Development Facilitation Team (DFT) – Review Comments

DRB Project No: PR-2020-004448 Date: 01/24/2023 Agenda Item: NA Zone Atlas Page: Q-16

Location: 5201 Hawking Dr. SE

Application For: SI-2023-00132 – Site Plan DFT (DFT)

UT 5

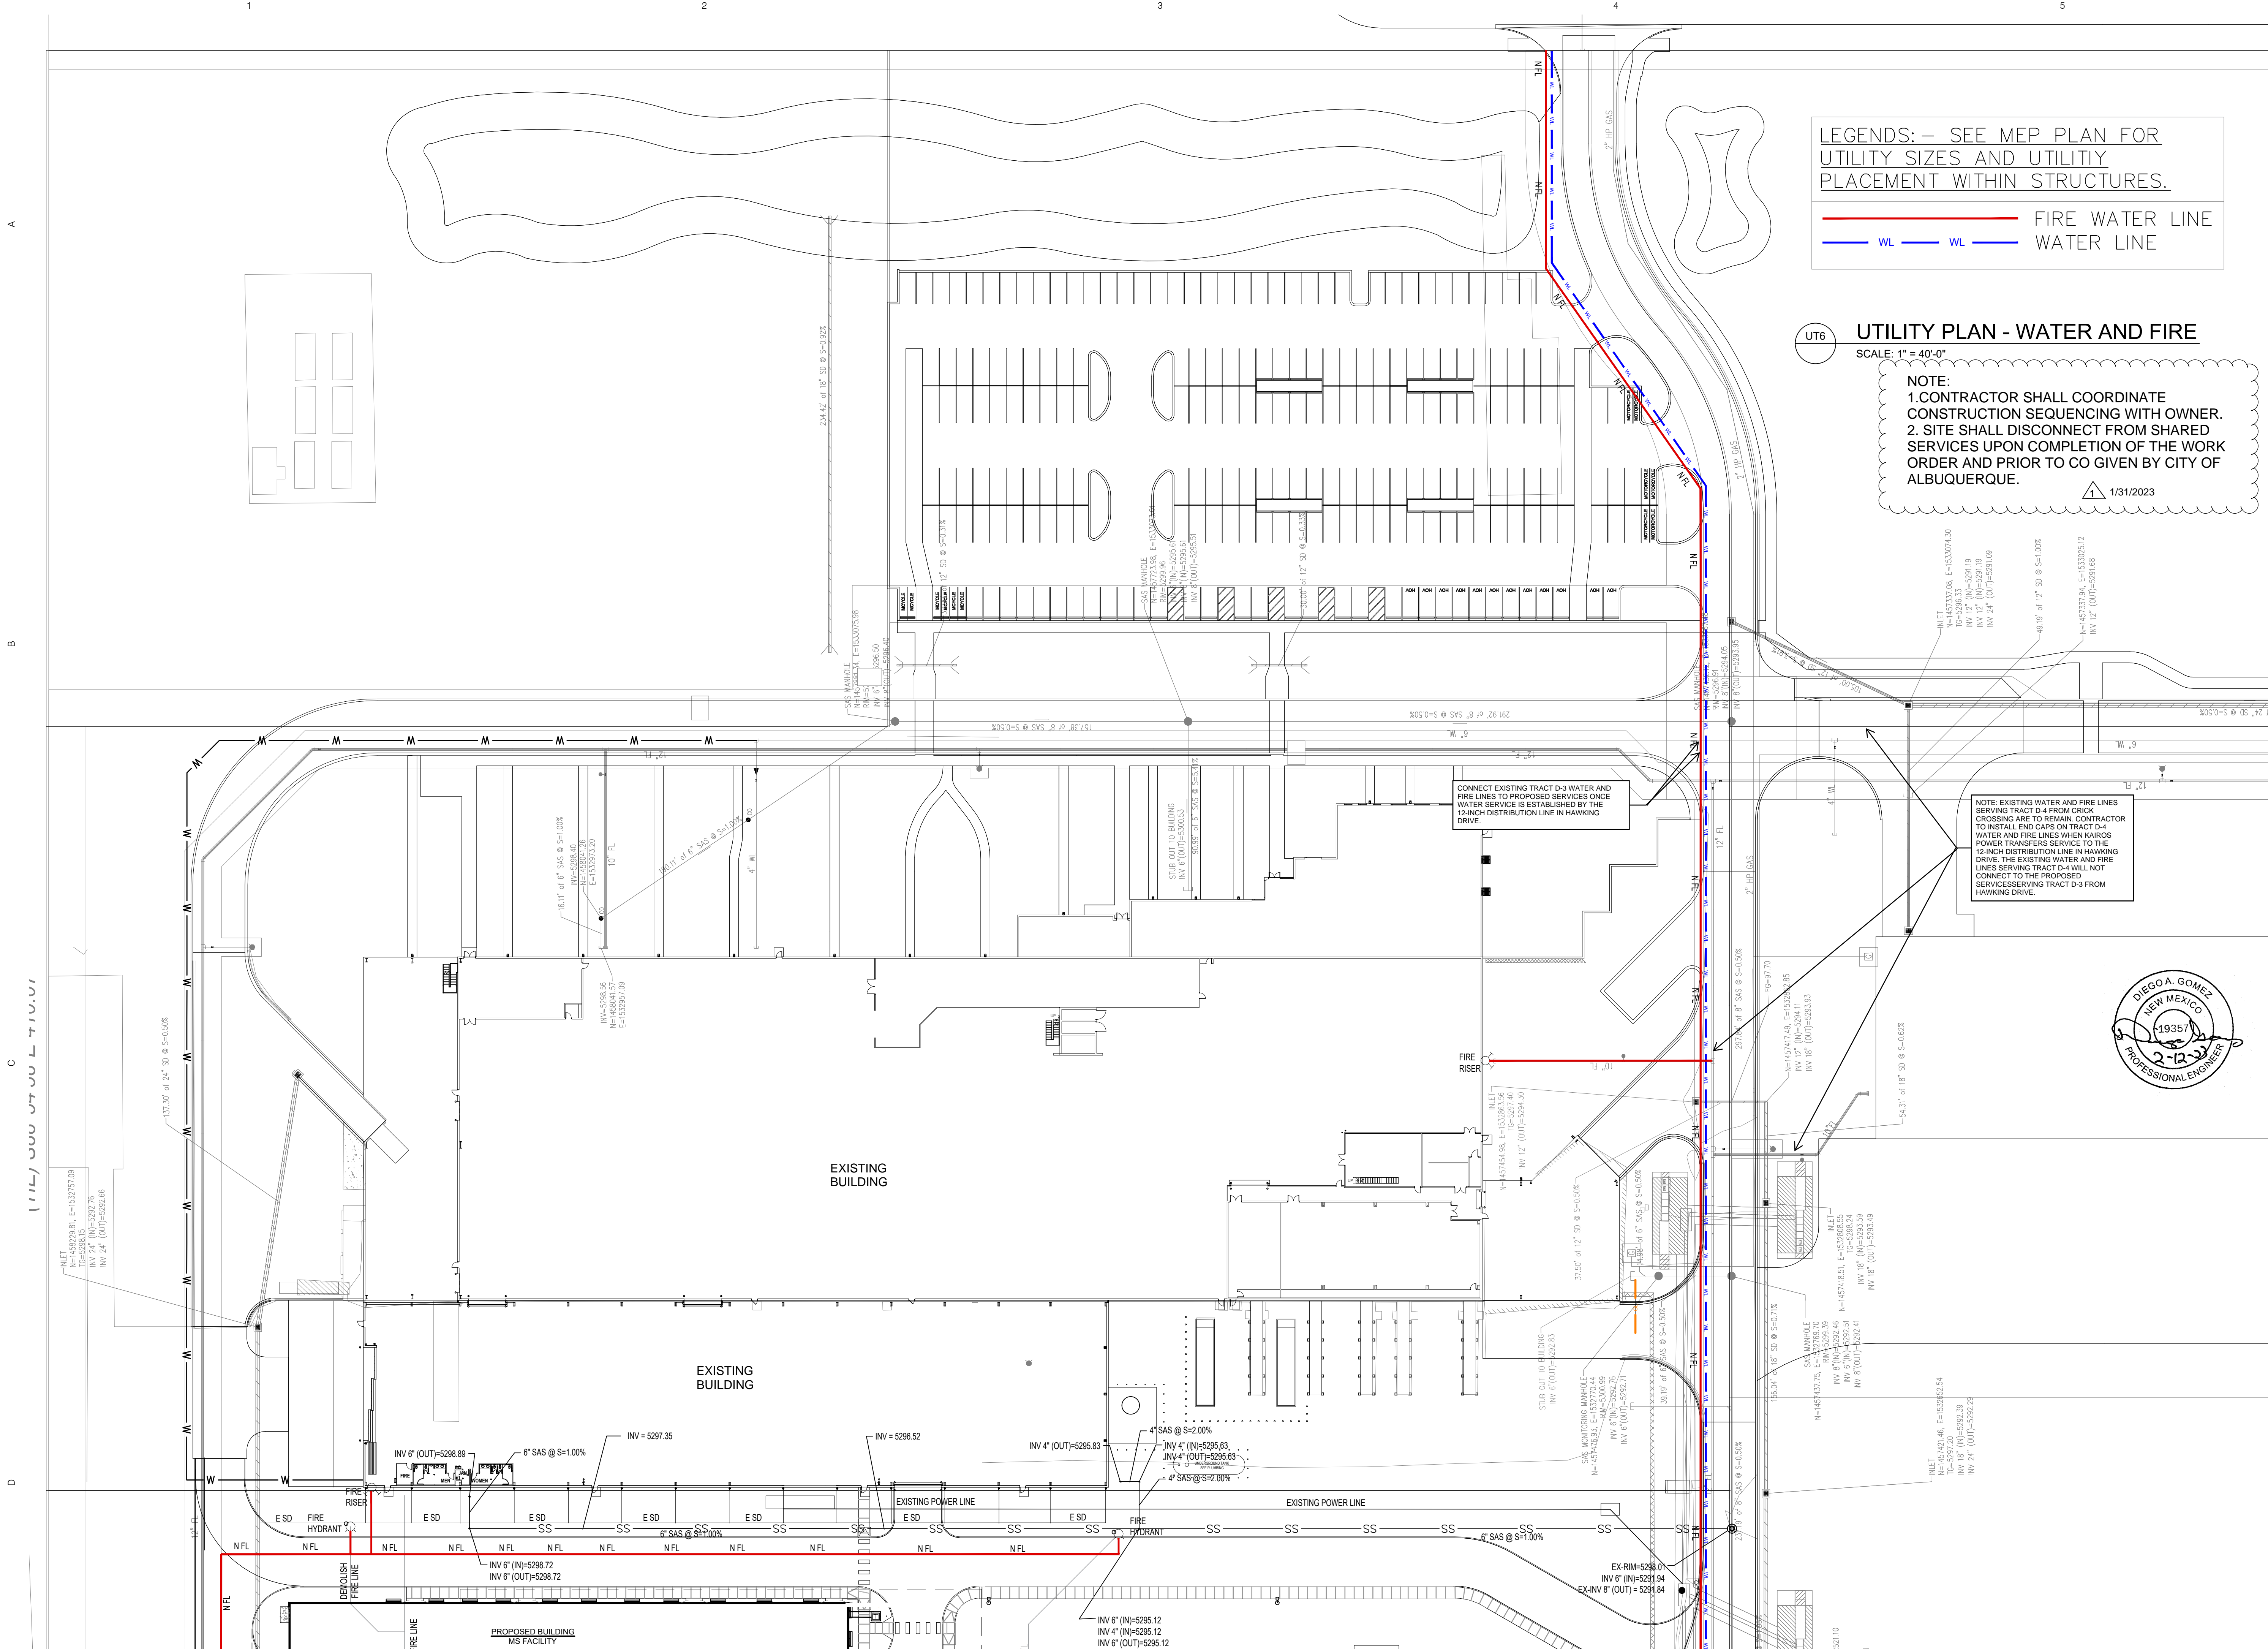
3. Ensure a note is placed on the utility plan stating that the site shall disconnect from the shared service upon completion of the work order and prior to CO given from the City of Albuquerque.

- a. Clearly show the disconnect on the utility plan.
4. Please show the newly proposed services along Hawking along with the new public infrastructure along Crick and Hawking on the overall Utility plan. Clearly define the sizes of all infrastructure and label each item as public or private.

5. Please add the following notes to the utility plan:
 - a. Coordination with Water Authority Cross Connection Section will be required to ensure proper backflow containment is in place prior to release of meter for the site. Contact the Cross Connection Section at 505-289-3454.

- b. Coordination with the Water Authority Pre-Treatment Engineer is required to ensure the site complies with Water Authority Sewer Use Ordinance. Contact the Pre-Treatment Engineer at 505-289-3439.
